# CITY OF ALBUQUERQUE

RE: **THE TRAILS - UNITS I, II & III**  
**Amendment to the Drainage Master Plan**

**File: C09-D001**  
PE Stamp: 11/25/2013

City Project No.	Zone Map No.	PLATE 1
730084	C-9-Z

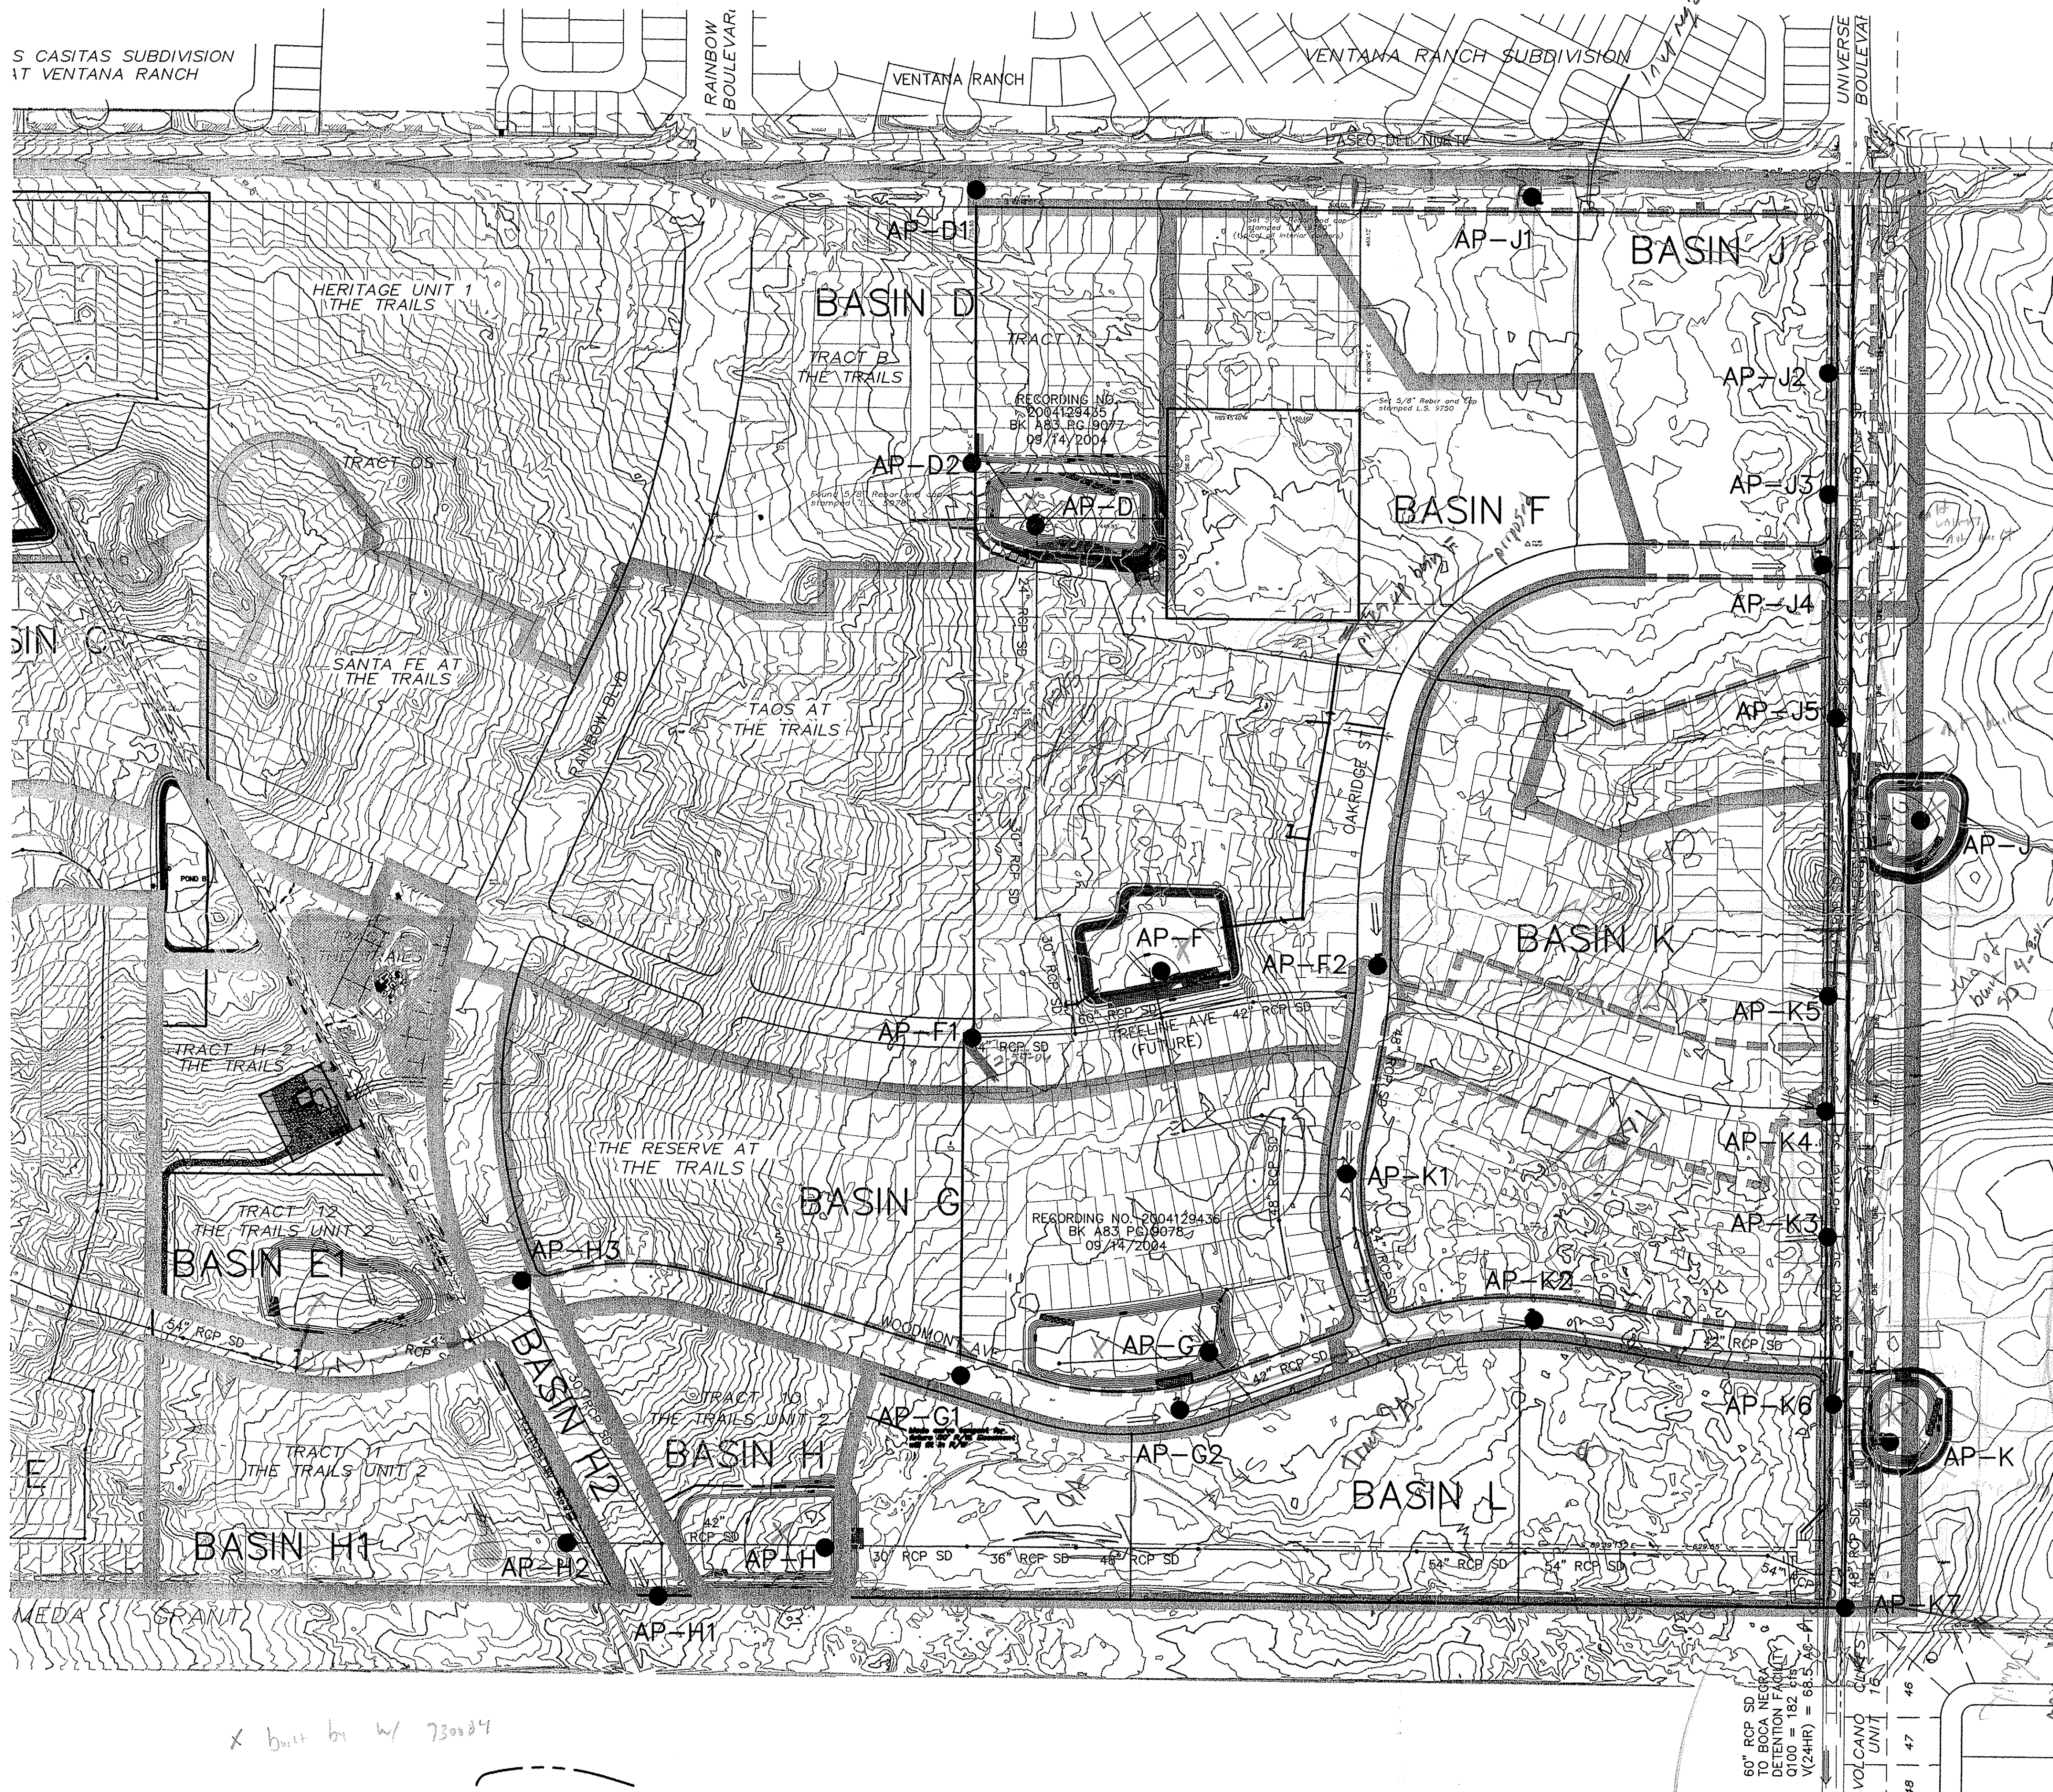
- e. *Item 10:* Provide City Project Numbers (CPN) on existing storm drains and ponds on Plates. Restore pipe sizes and Q's that were on the previous Plates and have been omitted on this edition.

5. DMP presentation comments:
- a. Clearly label this DMP and the Plates as Amendment to DMP for The Trails Units 1, 2, and 3.
  - b. Plates are intended to provide a visual summary of the DMP facilities and modeling results, to serve as a quick reference for future development use. This includes the previous request to include Line sizes and Q's on all pipelines, and CPNs on the existing lines.

- c. Some of the Basins shown on the Plates do not have flow arrows indicating modeled outfall points. Please update Plates to include flow arrows on all basins, and show the associated  $Q_{100}$  on the plan or Basin Summary Table.

- e. Add a “Basin Summary” table to the Plates, including, at least the following:  
Basin No. – Area (Ac-Ft) – Yield (cfs/Ac) – Q<sub>100</sub> (cfs) – V<sub>100-24</sub> (Ac-Ft)

- f. Add a note on Plate 2 showing the intended, Future Contribution of 20 cfs flow from The Trails Unit 4, east of Universe Boulevard.
- g. Add a note in the Report and on the Plates stating that the line sizes shown are based upon 100-year, 24-hour storm flows, and that future development projects may have to upsize pipes to accommodate 100-year, 6-hours storms during subdivision design.

- n. Provide a BOLD note on each Plate, and a statement where appropriate in the report, to identify what datum is referenced for the elevations used in the report (?NAD 1929?).
